Our ref: DOC25/557257-12

EPA Advice on Modification Report – Kurnell Terminal – SSD-5544 MOD-7

I am writing in response to your request for the NSW Environment Protection Authority (EPA) to review the Modification report for the proposed Kurnell terminal (Application SSD-5544-MOD-7) at 2 Solander Street Kurnell.

Copyright: Copyright in material relating to the base layers (contextual information) on this page is licensed under a Creative Commons Attribution 4.0 Australia licence © Department of Customer Service 2020, (Digital Cadastral Database and/or Digital Topographic Database).

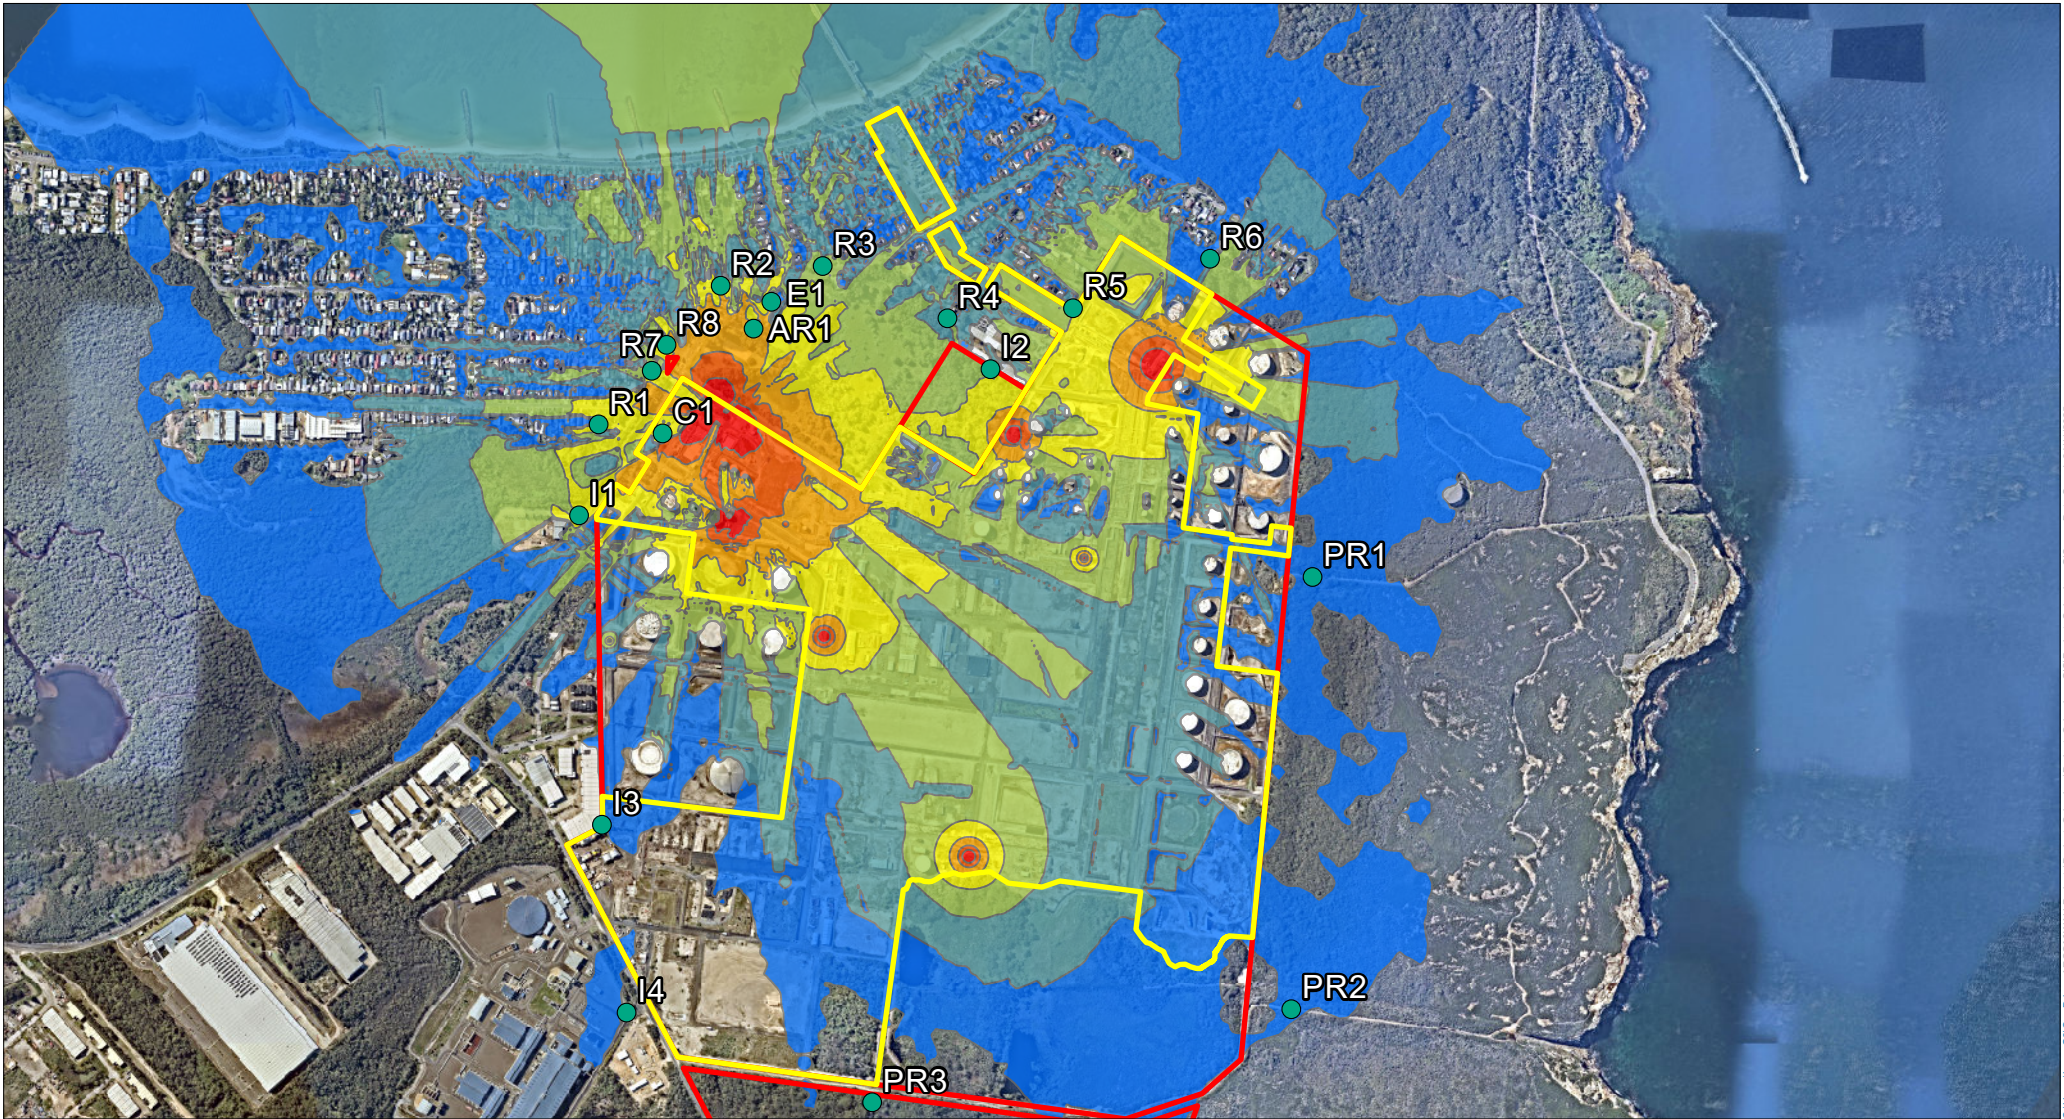
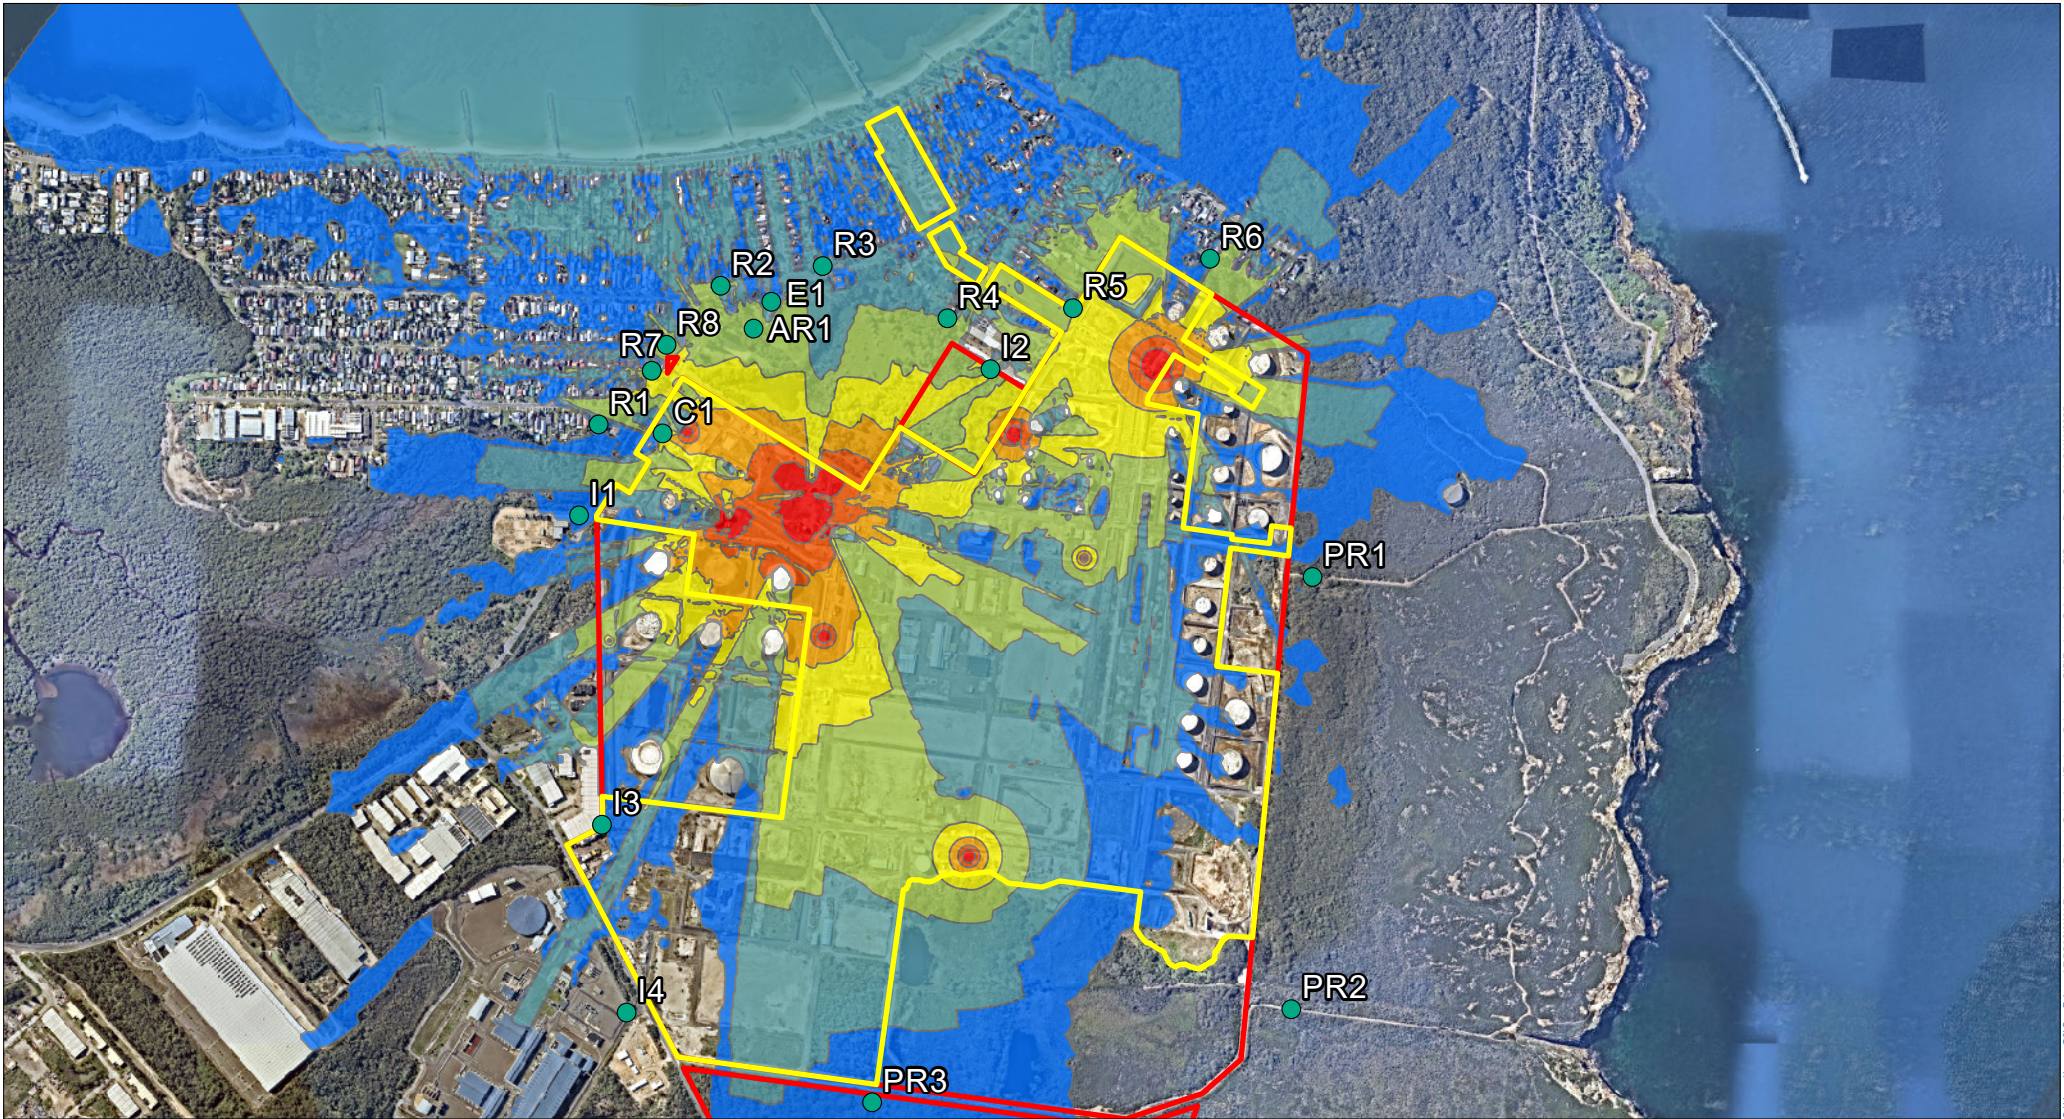
The noise contour maps in Appendix B only show noise levels between 50 and 60 dBA up to 80 dBA. This presentation makes it difficult to understand how noise propagates through the residential areas.

The EPA recommends the operational noise contours are presented to a minimum level of Leq,15min 35 dBA and are provided for review.
